Gleneagle F2 Punch List Items (*map does not include all items)

DESIGNED		DRAWN		CHECKED		DATE	
RESPEC	MAR	RESPEC	MAR	RESPEC	MAR	RESPEC	MAR
720 S COLORADO BLVD		720 S COLORADO BLVD		720 S COLORADO BLVD		720 S COLORADO BLVD	
SUITE 410S		SUITE 410S		SUITE 410S		SUITE 410S	
DENVER, CO 80246		DENVER, CO 80246		DENVER, CO 80246		DENVER, CO 80246	
PHONE (303) 757-3655		PHONE (303) 757-3655		PHONE (303) 757-3655		PHONE (303) 757-3655	
Know what's below. Call before you dig.							
PROJ NO. 03524 DWG NO. 03524-Dev-F12							
GUMAN & ASSOCIATES, LLC 731 N. WEBER ST., SUITE 10 COLORADO SPRINGS, CO 80903							
GLENEAGLE SUBDIVISION FIL #2							
DRAINAGE, GRADING & EROSION CONTROL PLAN							
DRAWING NUMBER:							
EPC 6/4/19							
VR-18-018							
SHEET 2

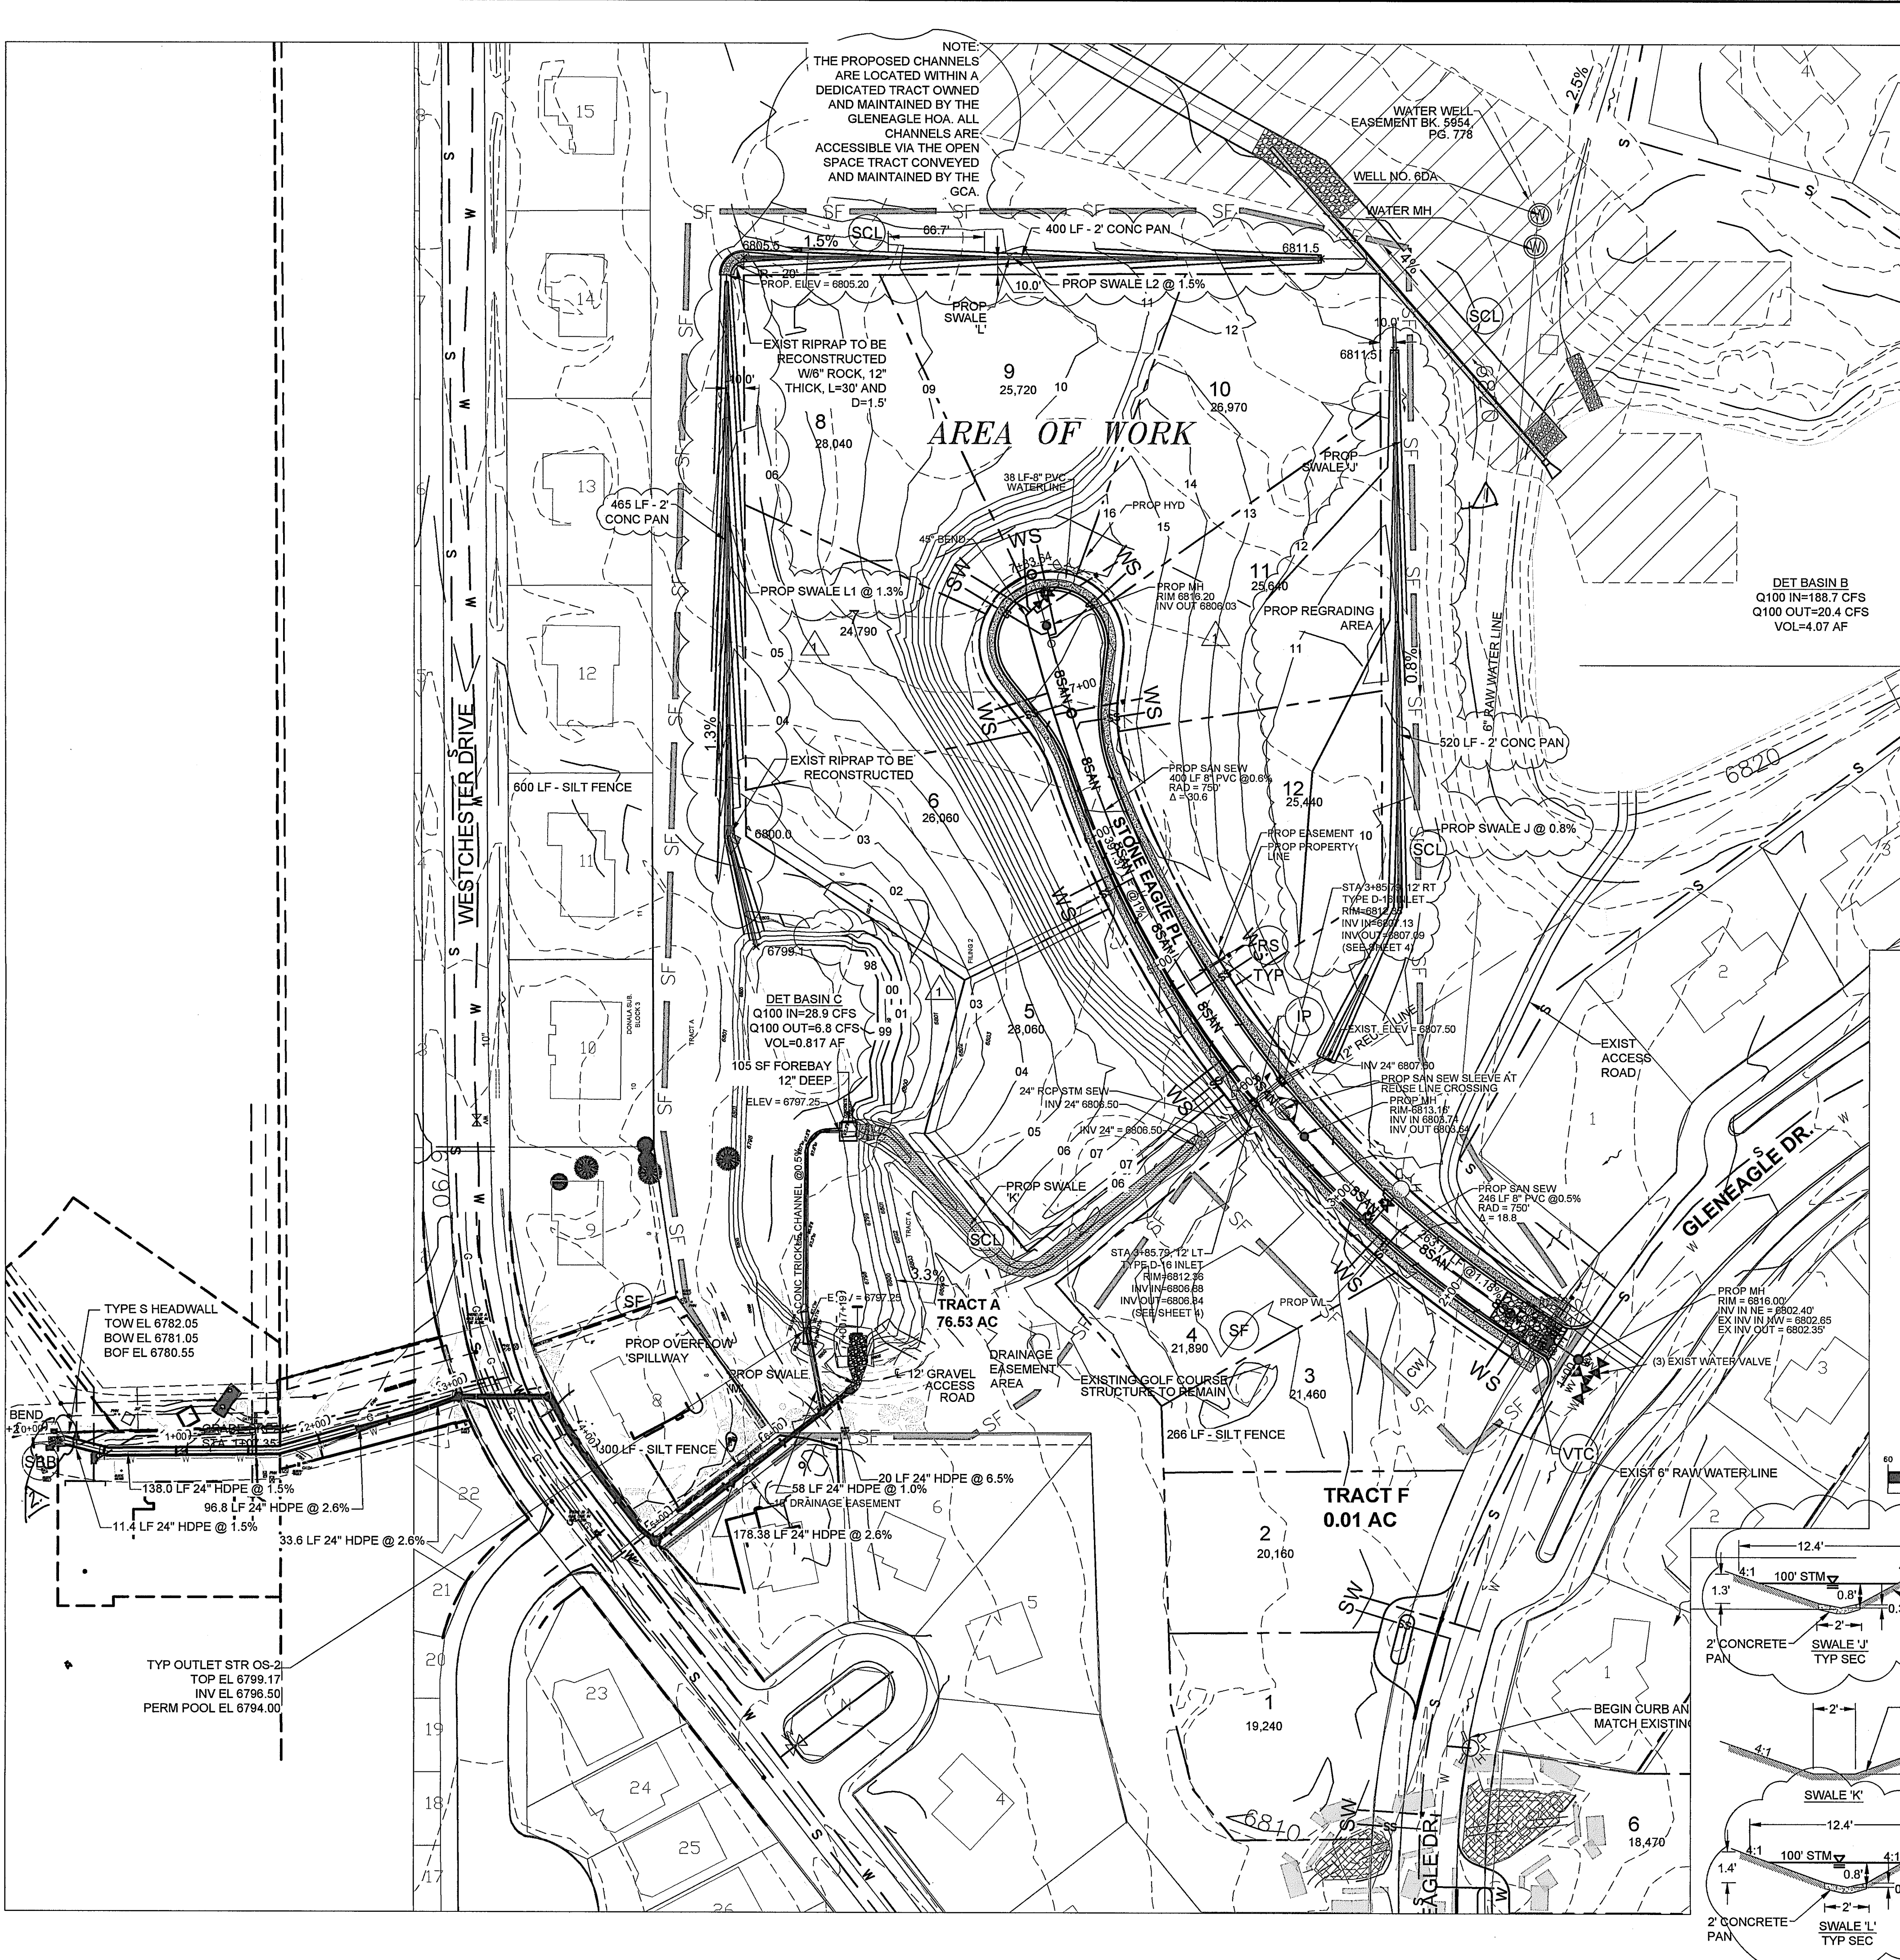
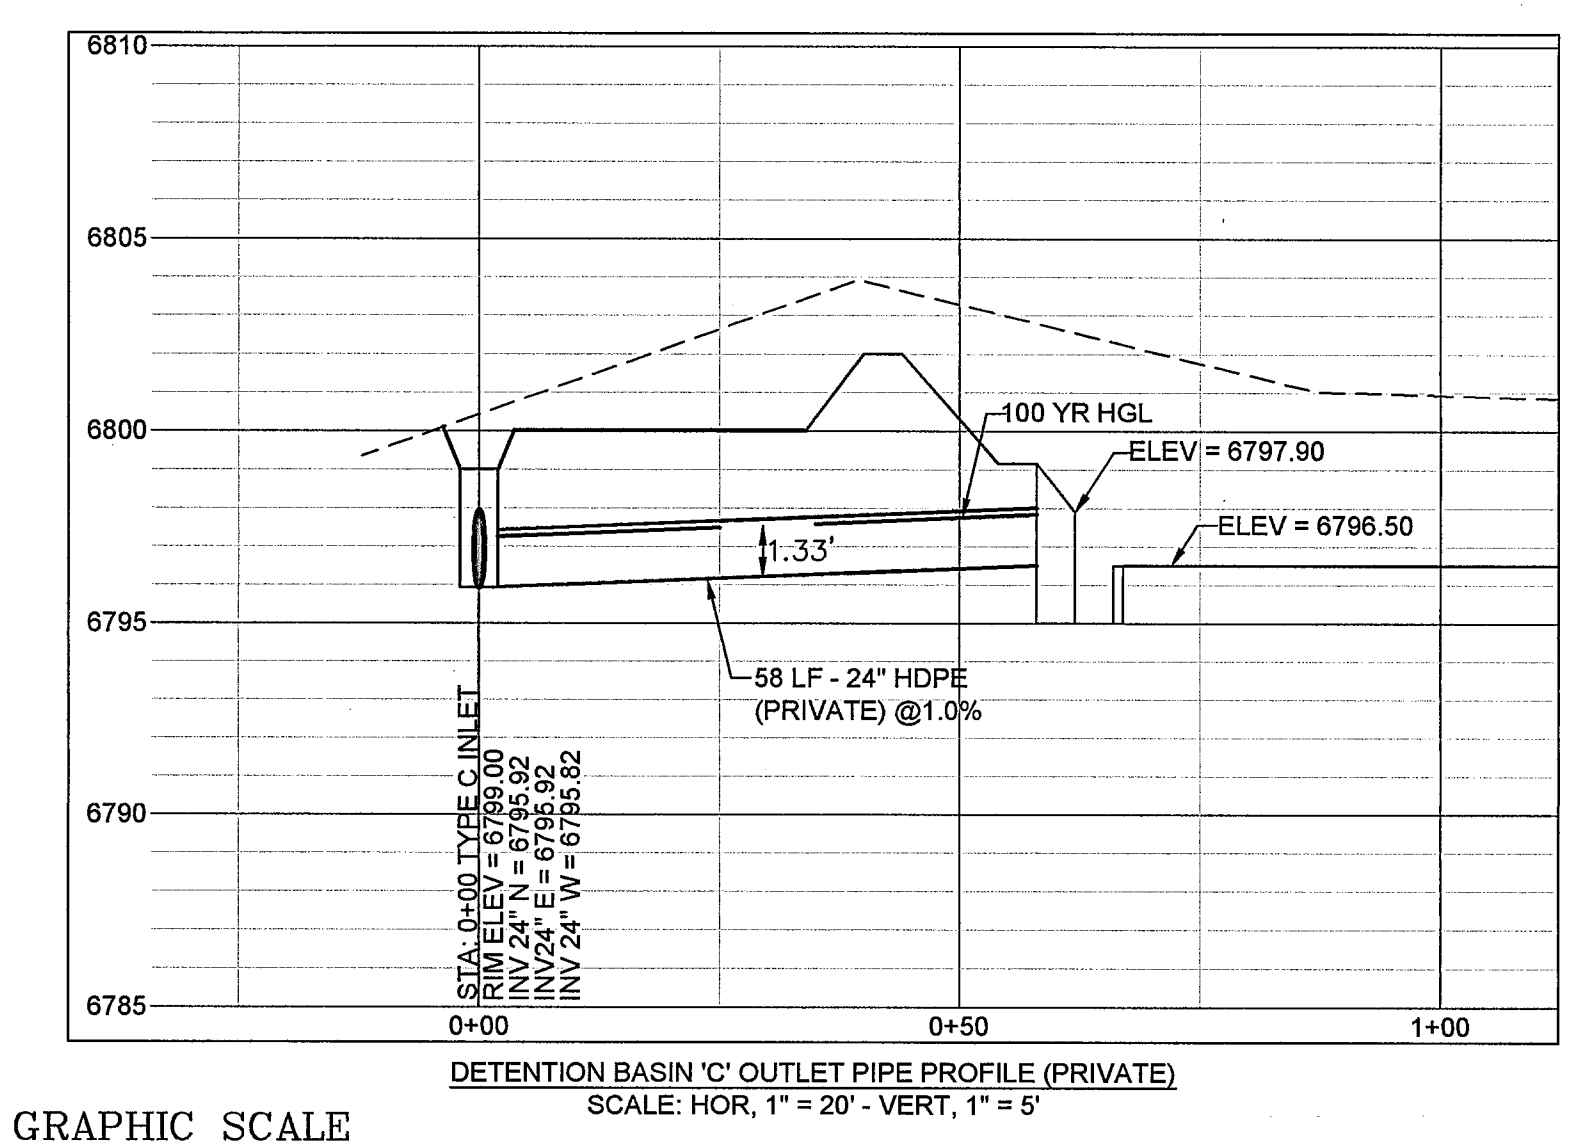
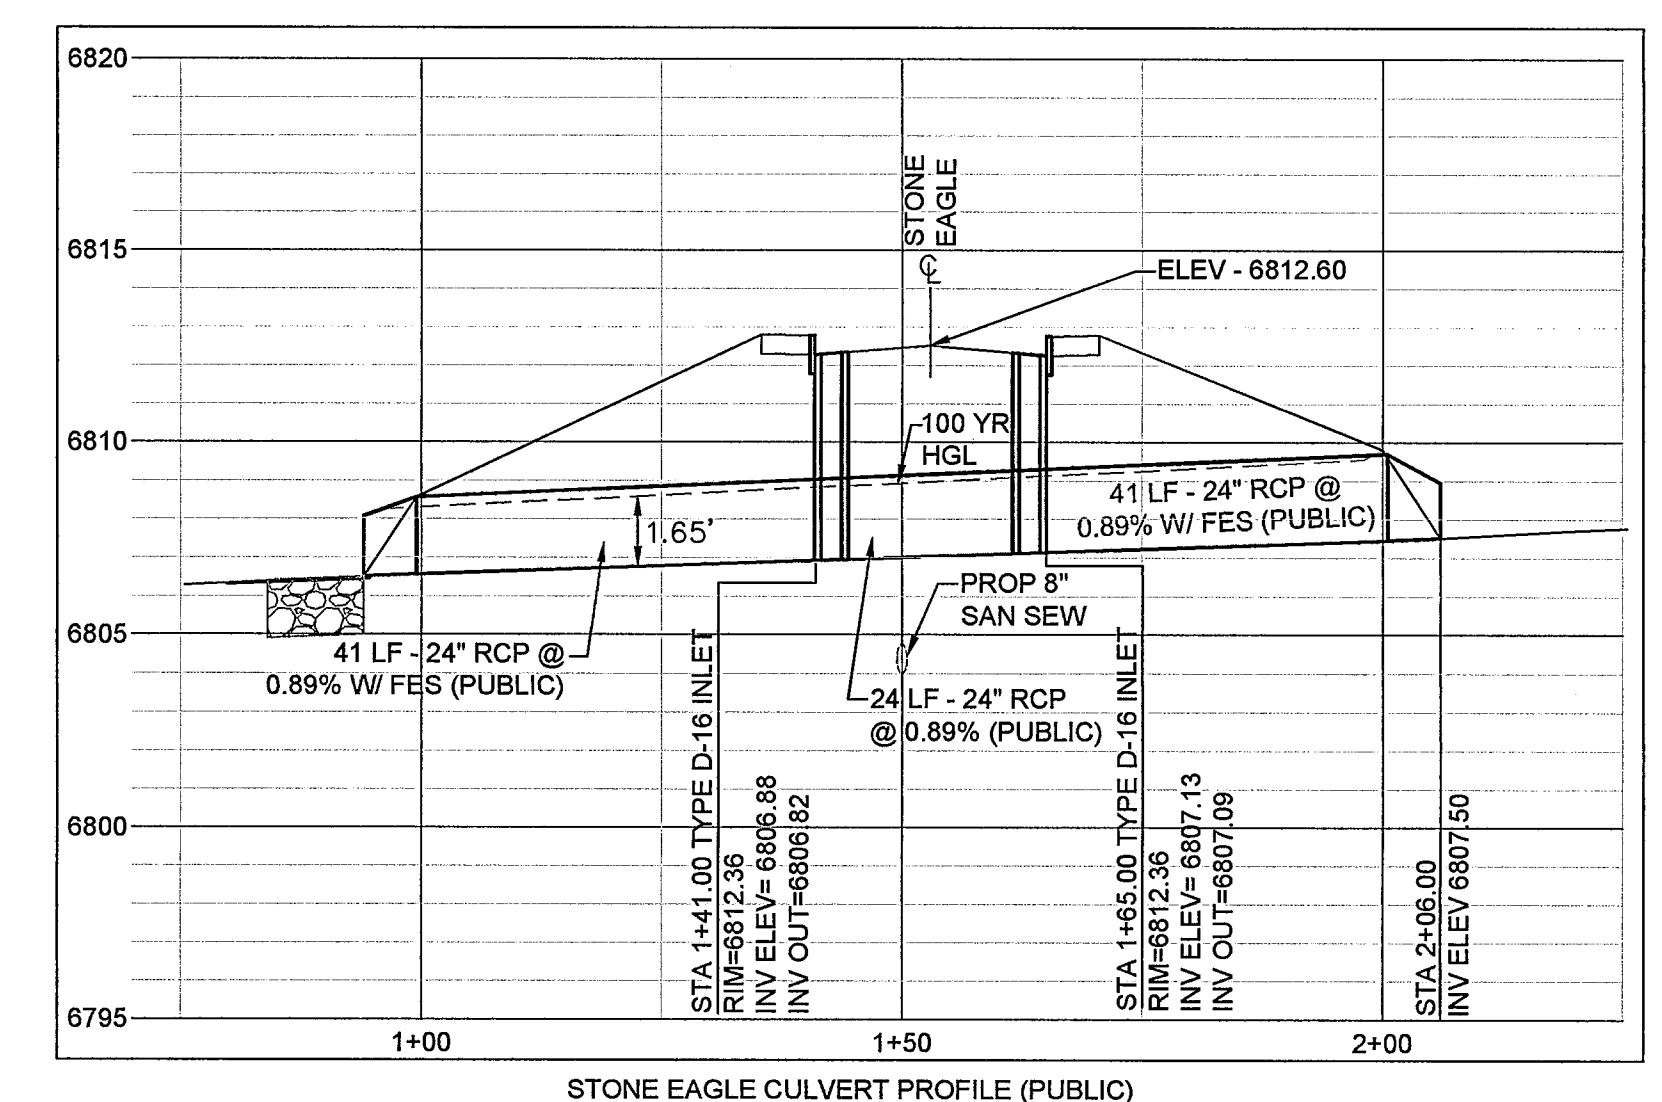
Damage by Builders. This should be a builder responsibility

Implement stabilization

Remove straw wattle

Remove straw wattle at end of concrete

Remove accumulated sediment

Photo 3 - remove straw wattle

Photo 5 Behind lots 6-8

Repair erosion along concrete swale

Photo 1 - stabilize slope of swale

Remove SW

Photo 7 - Address severe erosion in swale K

Address erosion in swale K
